**Re: A Façade Renovation
111 Cardenas NE
Traffic Circulation Layout
Engineer's/Architect's Stamp dated 10-22-15 (K18-D106)**

**Re: A Façade Renovation
111 Cardenas NE
Traffic Circulation Layout**
Engineer's/Architect's Stamp dated 10-9-15 (K18-D106)

Based upon the information provided in your submittal received 10-9-15, the above referenced plan cannot be approved for Building Permit until the following comments are addressed:

1 H.C. PARKING SIGN  
C1 NOT TO SCALE

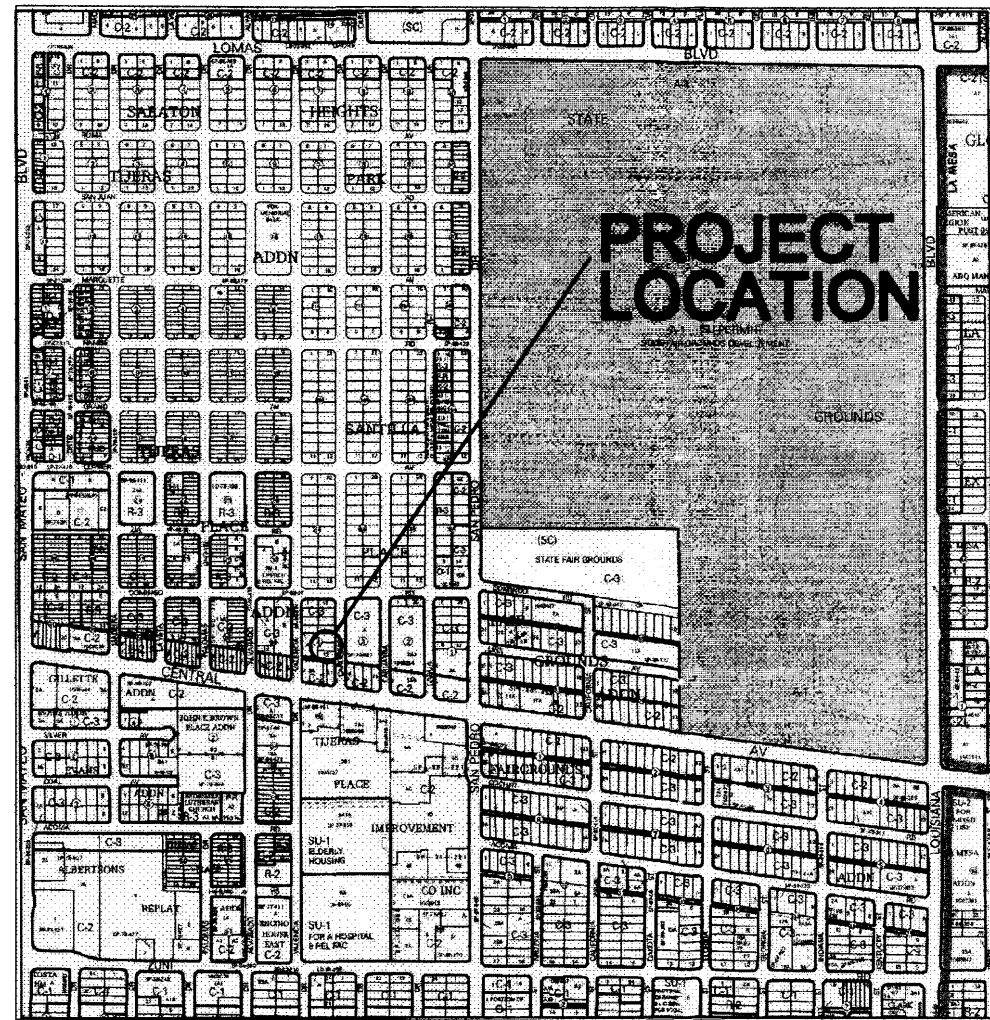
8. The ADA accessible parking sign must have the required language per 66-7-352.4C NMSA 1978 **"Violators Are Subject to a Fine and/or Towing."** Please show a detail of this signage.

TRAFFIC CIRCULATION PLAN 111 CARDENAS DR NE  
1/16" = 1'-0"

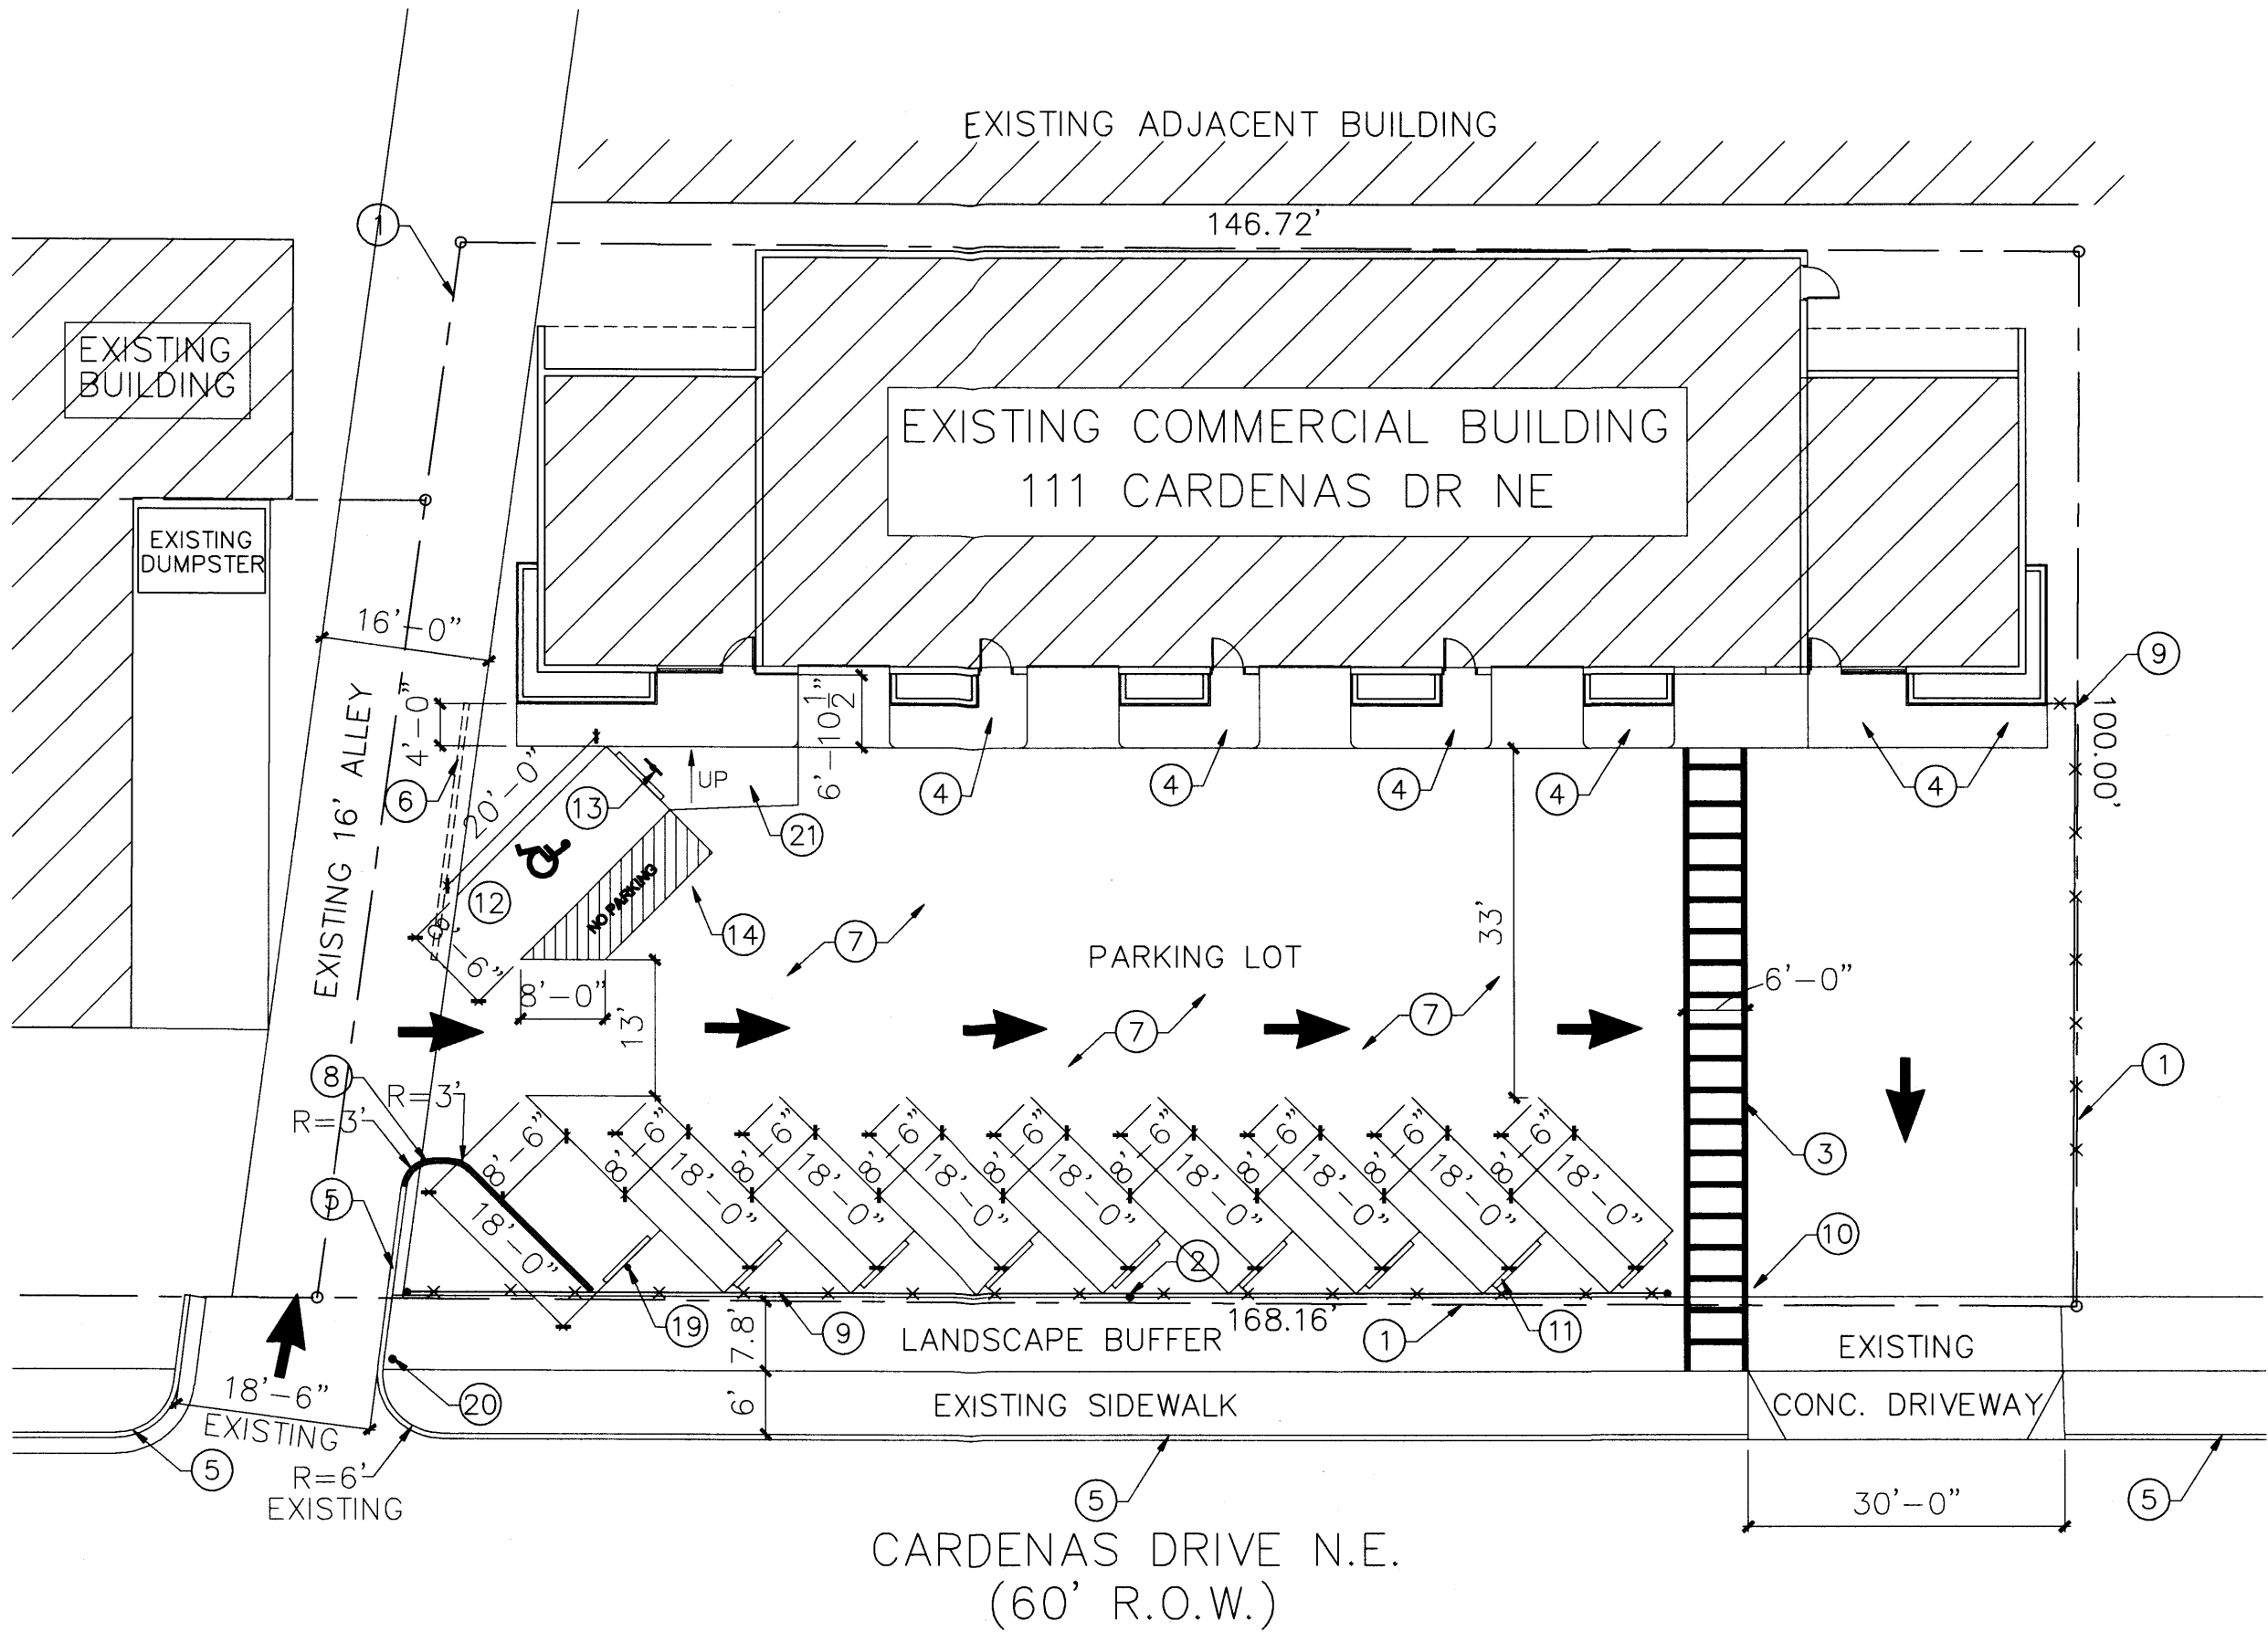
3. Clarify the extents of the current phase.
4. Please identify all existing electrical and light poles that influence the parking and circulation on the site.

5. Identify all existing access easements and rights of way with dimensions.
6. Identify the right of way width, medians, curb cuts, and street widths on Cardenas Dr.

7. Please list the width and length for all parking spaces. Identify the distance between all angled parking spaces. Per DPM, there must be an 11 ft. drive isle between angled parking spaces.

10. Show all drive aisle widths and radii.

11. List radii for all curves shown; for passenger vehicles, the minimum end island radius is 15 feet. Landscape island radius for delivery trucks, fire trucks, etc. is 25 feet or larger

12. Per the DPM, a 6 ft. wide ADA accessible pedestrian pathway is required from the public sidewalk to the building entrances. Please clearly show this pathway and provide details.

13. Per the DPM, a 6 ft. wide ADA accessible pedestrian pathway is required from the HC parking stall access aisles to the building entrances. Please clearly show this pathway and provide details.

14. Provide a min 6" or max 8" high concrete barrier curb or other acceptable barrier between landscaping and parking areas and/or drive aisles.
15. Design delivery vehicle route needs to be shown.

16. Service vehicle and/or refuse vehicle maneuvering must be contained on-site; provide a copy of refuse approval.
17. It is not apparent what type of pavement surface is being proposed. A hard driving surface will be required as part of this proposed project for parking area and drive aisles. The drawing states that there is "existing earth", please clarify detail.

22. Unused curb cuts must be replaced with sidewalk and curb & gutter. A build note must be provided referring to the appropriate City Standard drawing.
23. Please include two copies of the traffic circulation layout at the next submittal.

2 CLEAR SITE TRIANGLE @ INTERSECTIONS  
C1 NOT TO SCALE

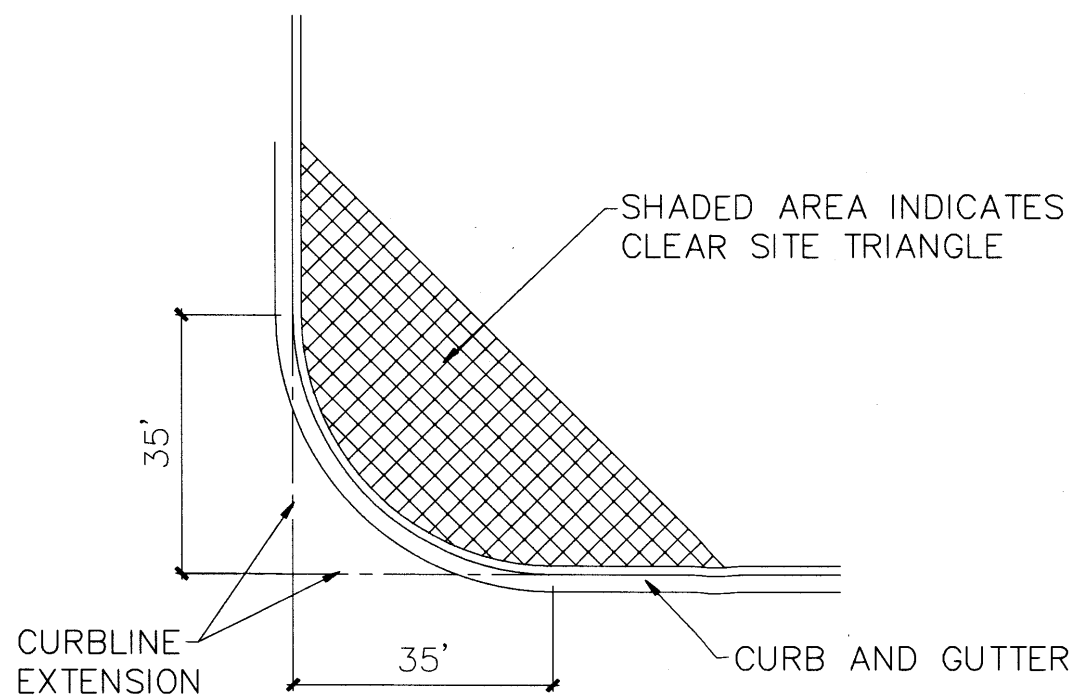
18. Please clarify how the site meets clear sight triangle requirements.
19. Please provide a sight distance exhibit (see the *Development Process Manual, Chapter 23, Section 3, Part D.5 Intersection Sight Distance*). Please provide this detail on Cardenas Dr.

20. Please add the following note to the clear sight triangle: "Landscaping and signage will not interfere with clear sight requirements. Therefore, signs, walls, trees, and shrubbery between 3 and 8 feet tall (as measured from the gutter pan) will not be acceptable in this area."
21. Please include a copy of your shared access agreement with the adjacent property owner.
